City of Portland, Maine - Building or Use Permit Application
 389 Congress Street, 04101 Tel: (207) 874-8703, Fax: (207) 874-8716

Permit No: 06-1542	Issue Date:	CBL: 083E A019001
------------------------------	--------------------	-----------------------------

Location of Construction: 42 Seal Cove Ln	Owner Name: Lee Judith K	Owner Address: Diamond Cove	Phone:
Business Name:	Contractor Name: Island Cottage/ Glenn Ruesswick	Contractor Address: P.O. Box 250 Kittery	Phone 2074393399
Lessee/Buyer's Name	Phone:	Permit Type: Single Family	Zone:

Dept: Zoning **Status:** Approved with Conditions **Reviewer:** Ann Machado **Approval Date:** 11/22/2006

REVISION HISTORY			
REV	DATE	DESCRIPTION	CHK
1	11/8/06	EAST-WEST	
2	11/20/06	PRE & POST GRADING BUILDING DIMENSIONS

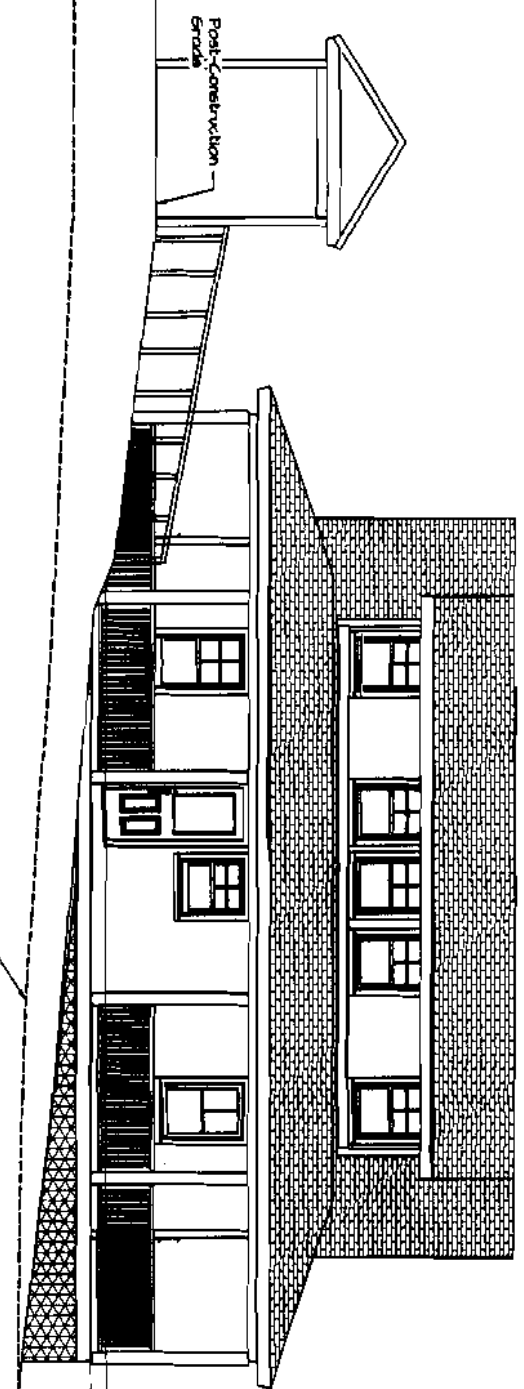
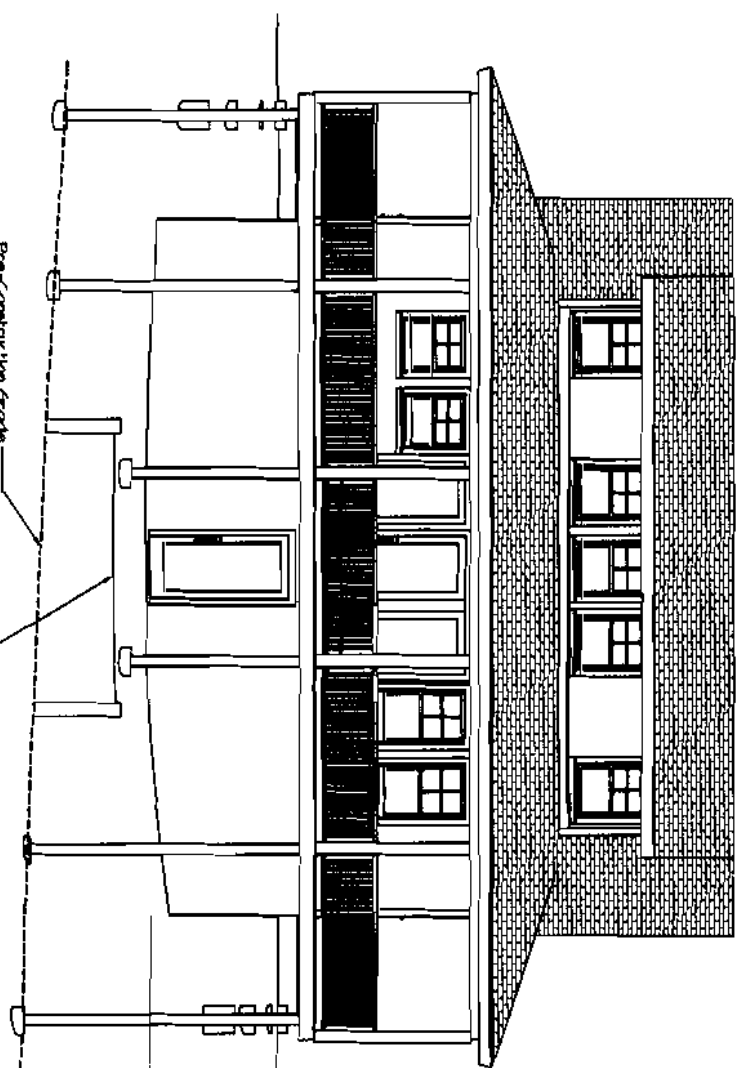
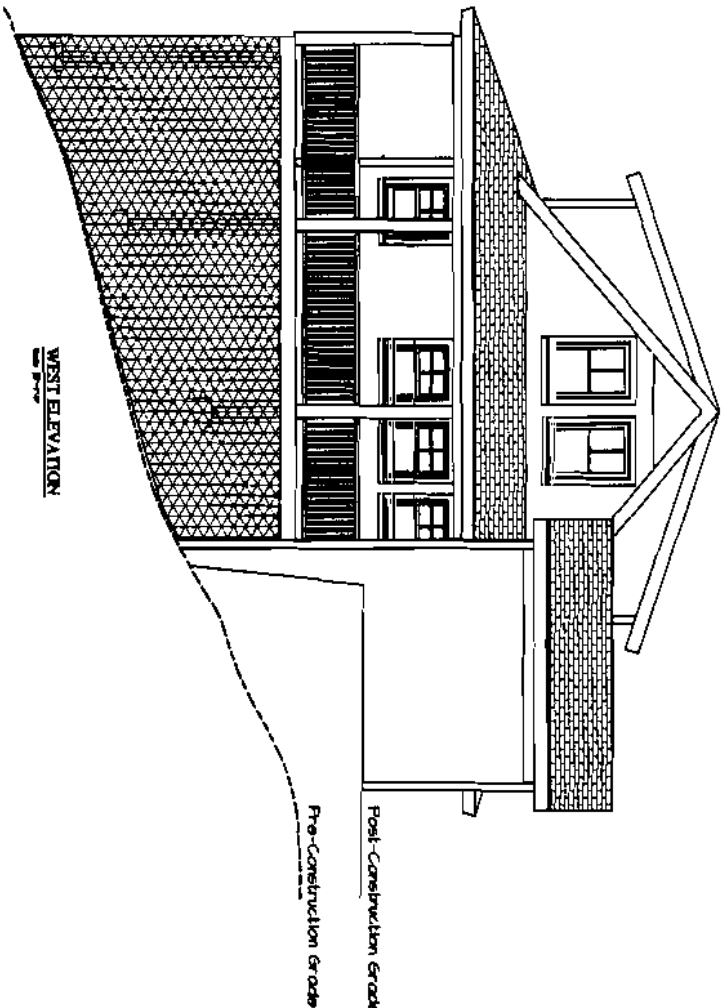
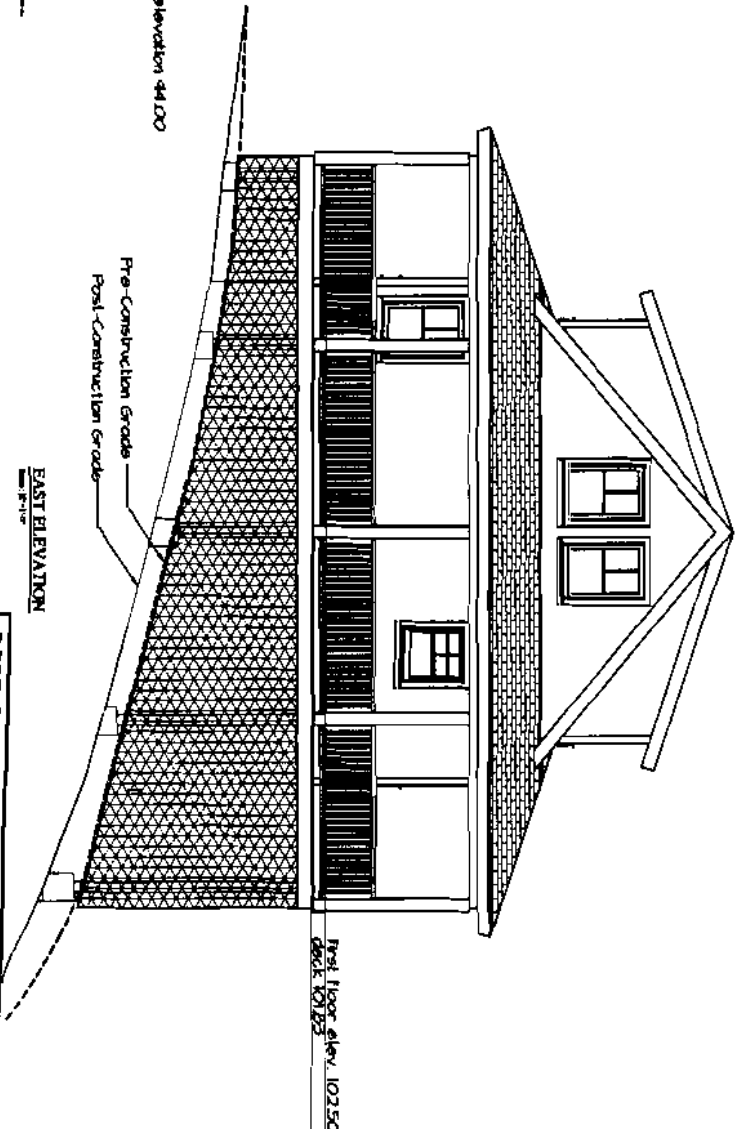
10/26/2006-amachado: Spoke to Glenn Ruesswick from Island Cottage. House and porch does not meet 30' front setback. We need to see both preconstruction grade and post construction grade on the elevation plans. We need to see two parking spaces beyond the front setback (they can be for golf carts). Glenn said that the garage is not being built. It needs to be removed from the siteplan if it is not being constructed. It also does not meet the 30' setback. Glenn said that Alex Ross, the engineer, would call me.

11/15/2006-amachado: Received revised site plan. The front setback is now being met & the two parking spaces are being shown for the golf carts. The footprint of the building and the porch is 43' x 36'. The building plans have it as 45' x 36'. Which is it? Elevation plans still don't show pre & post construction grade. They might not be changing but we need this confirmed in writing,
11/17/2006-amachado: Forwarding permit to Residential Plan Reviewers.
